Planning Application Ref: BE/12/17/DOC

Location: Former Healthcare Land at Bersted Park Site 6

Description of works: Conditions 8 & 10 – Landscape Scheme

Scale
1 : 250@A0
Drawing No.
D1530.L.901

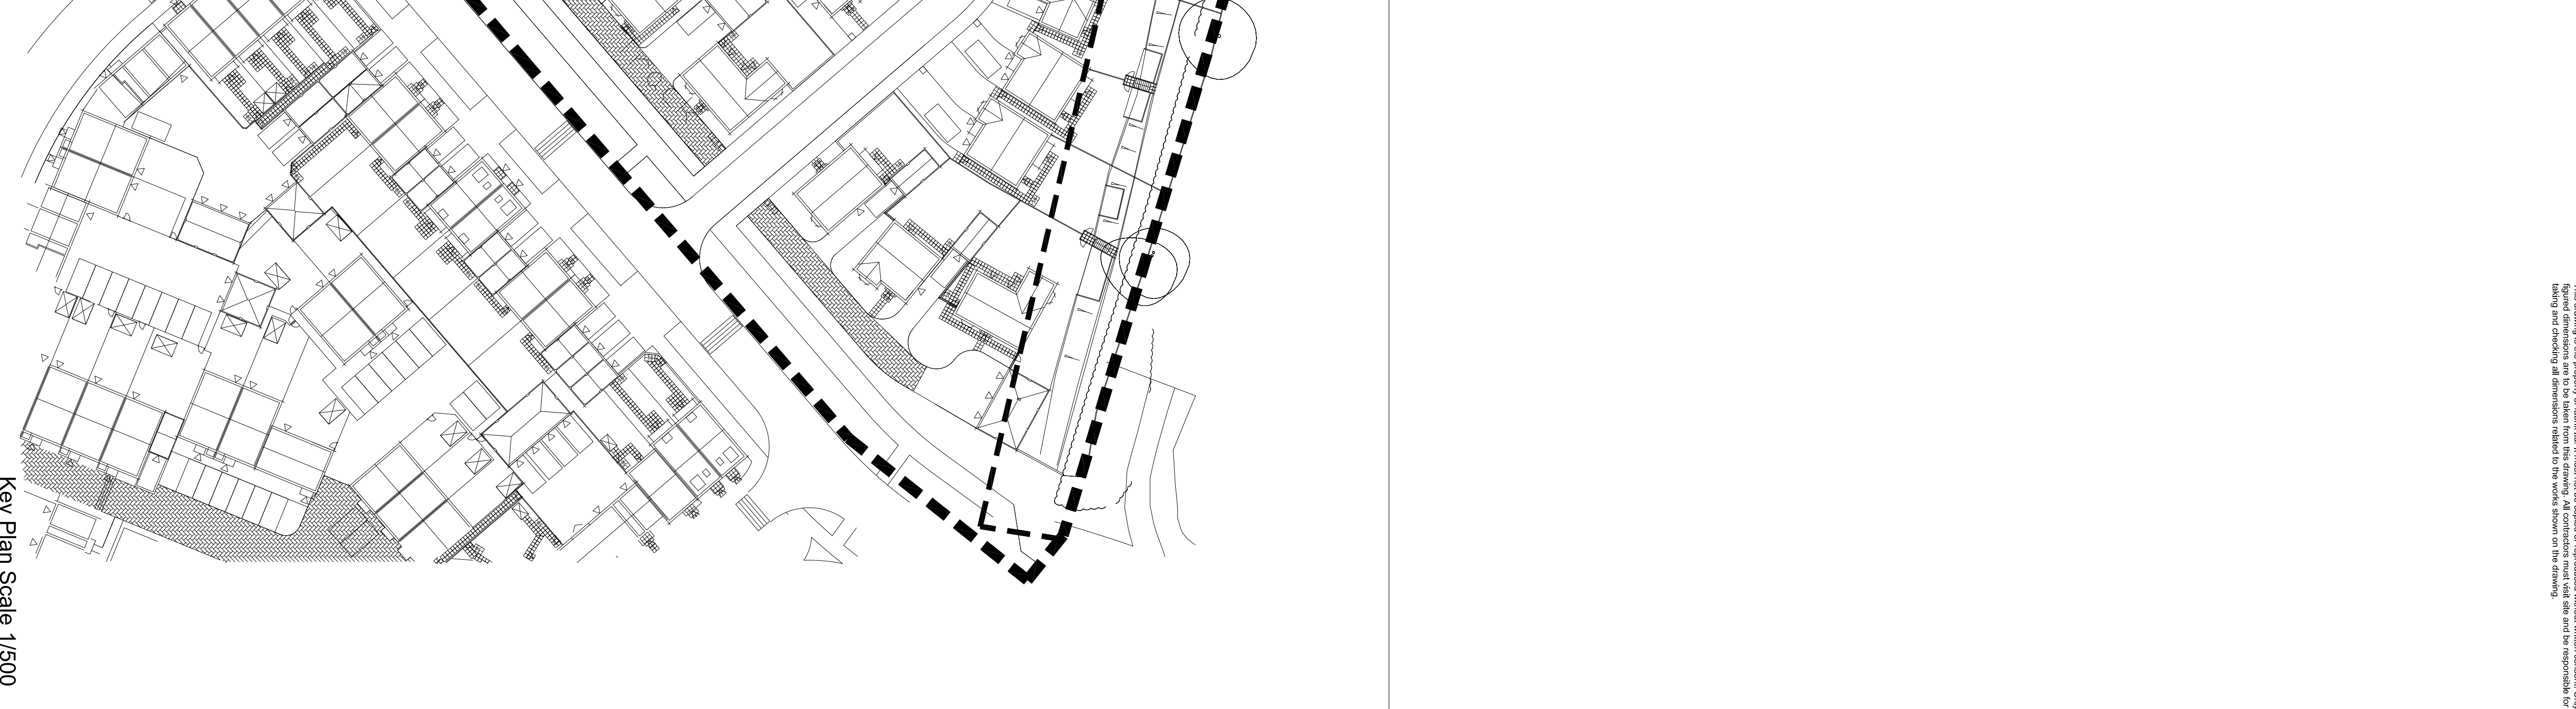
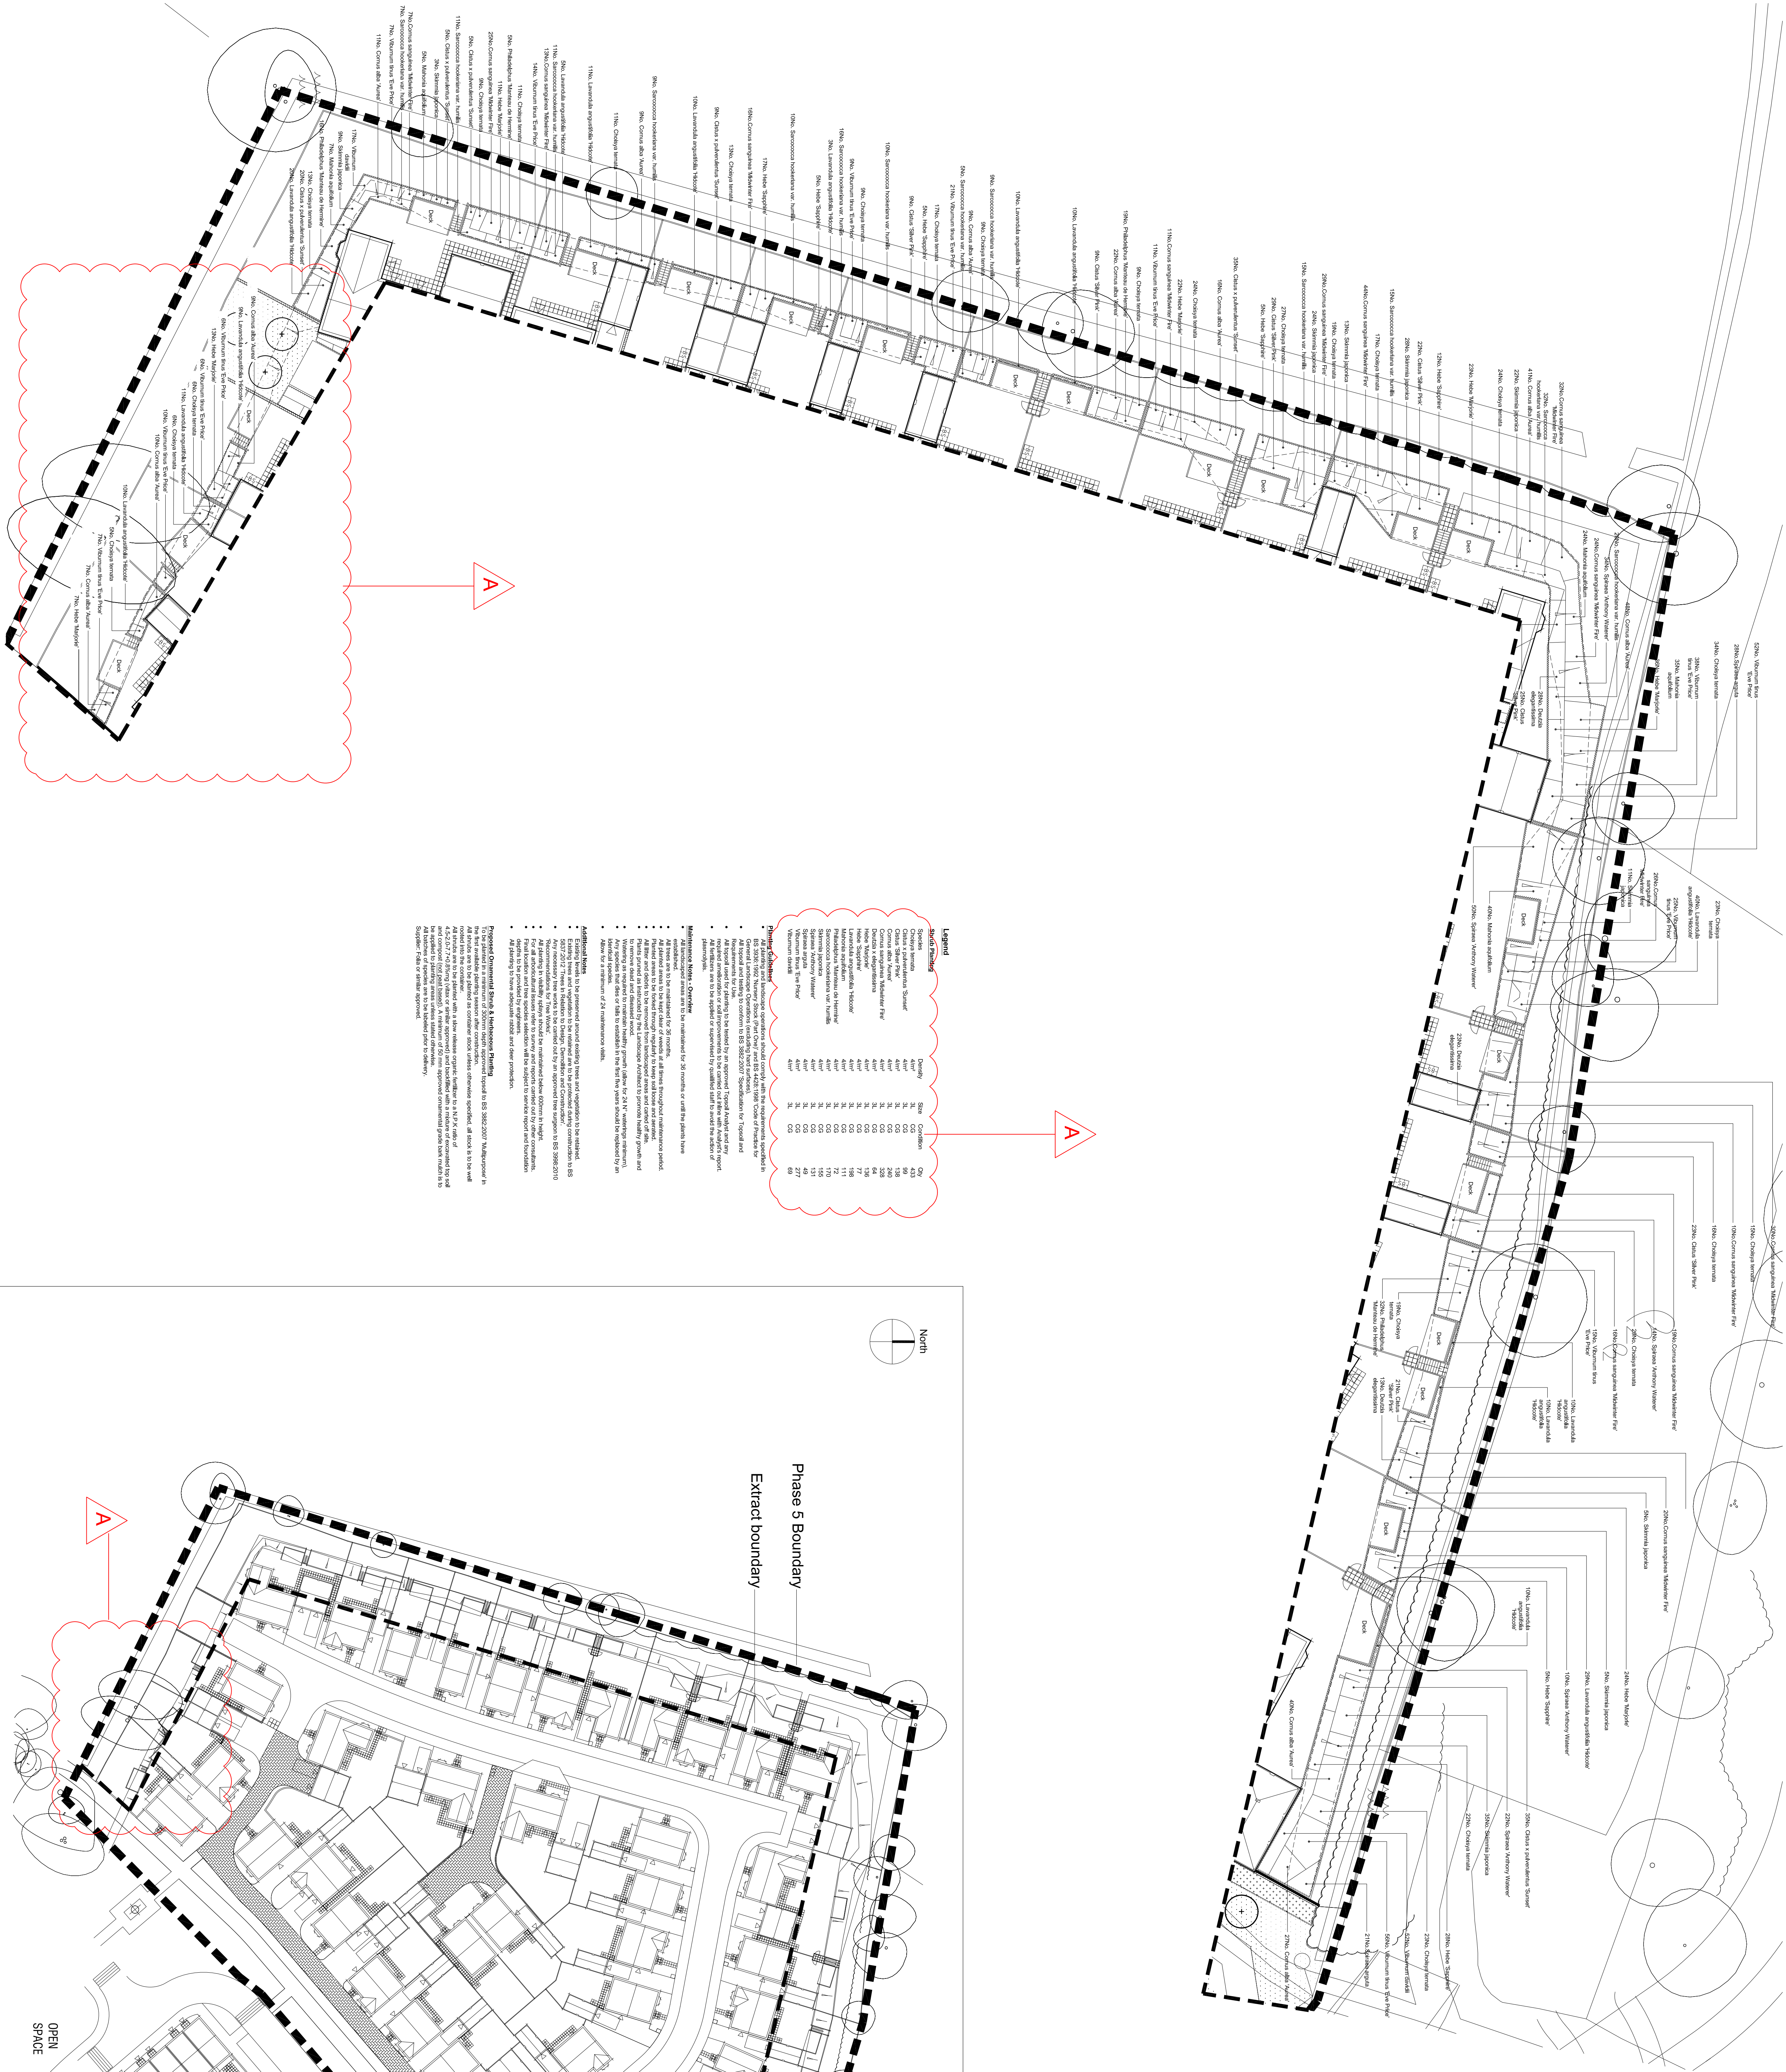
- This site is an active building site although works through this area seem to have been completed.
- The Conditions relate to Landscape Schemes so I defer to Sue Howell (Landscape Officer – Greenspace) for her comments on this.
- However, I would add that the FABRIK plans Tree Removal & Protection Plan (Sheets 1 & 2) state that the footpaths are to be of 'No Dig' Cellular Confinement system construction form whereas what I saw on site appeared to be finished paths that were tarmac hard surfaced.
- It is not possible to determine after the fact whether any root damage occurred during this process and it can take up to three to five years from completion of work for any signs of dieback to appear in trees that have suffered root damage of any sort.
